While looking through the plans of this application I have noticed some issues on the proposed block plan and elevations.

Arun District Council, Civic Centre, Maltravers Rd, Littlehampton, West Sussex, BN17 5LF
www.arun.gov.uk

**257 GORING WAY, FERRING,
WEST SUSSEX, BN12 5BY**
 DRWG 257GW 005 PROPOSED
 ELEVATIONS / SECTIONS
 SCALE 1:100 @ A3
 PLANNING DRAWINGS
 15.02.2021
 (REV A - 23.02.2021)

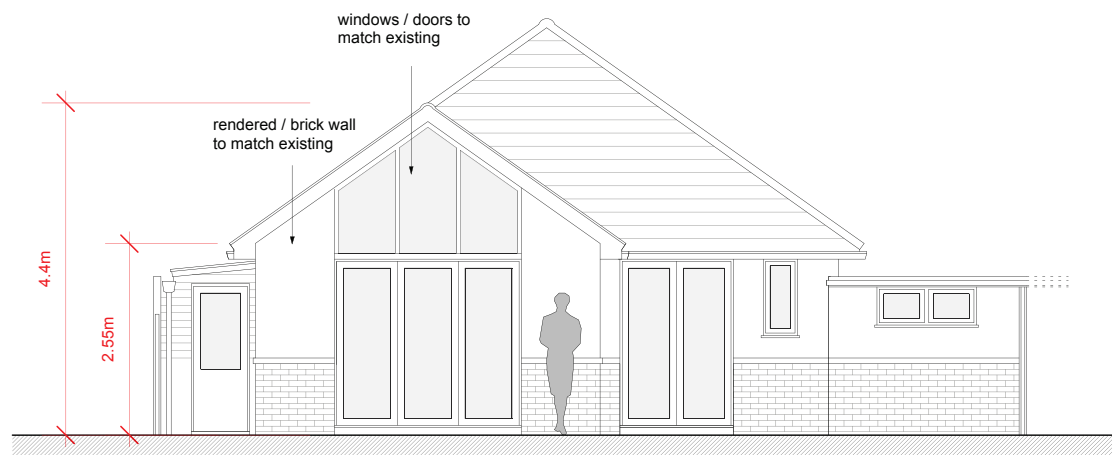
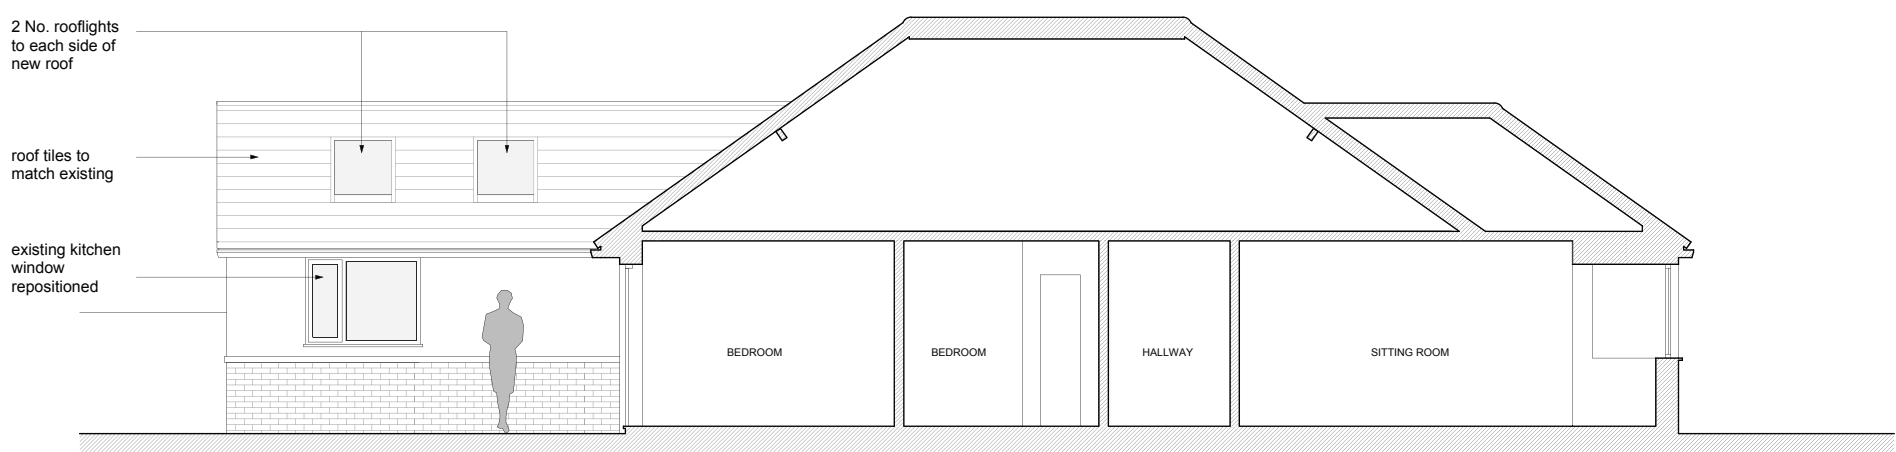
I will also need a revised proposed elevation plan. The current plan labelled 'proposed section and elevation 005' shows the sections labelled AA, BB and CC. However, I require a separate plan to show the proposed elevations labelled North, East, South and West as well as front, rear and side.

Further to our telephone conversation just now, I'm attaching a Proposed Location / Block Plan, and the existing and proposed elevations with amended annotation.

**257 GORING WAY, FERRING,
WEST SUSSEX, BN12 5BY**
 DRWG 257GW 001 LOCATION & BLOCK PLANS
 SCALE 1:1250 / 1:500 @ A3
 PLANNING DRAWINGS
 15.02.2021
 (REV A - 23.02.2021)

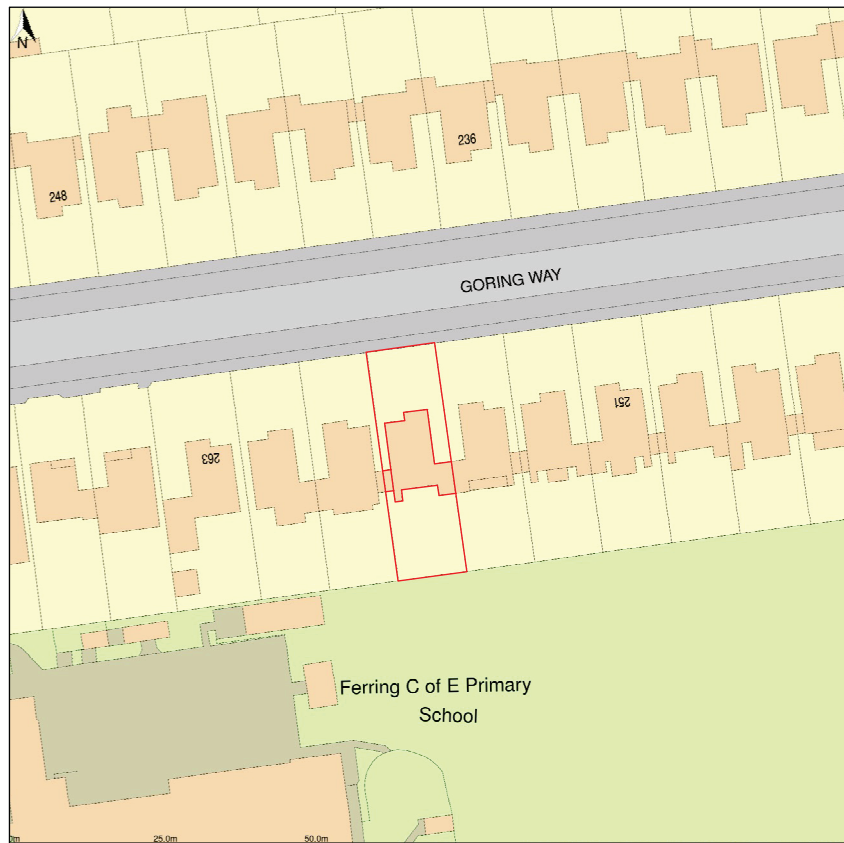
Please would you be able to send in a revised proposed block plan to show the proposal on the plan. Therefore, I will be able to work out the boundaries of this development to the neighbouring properties.
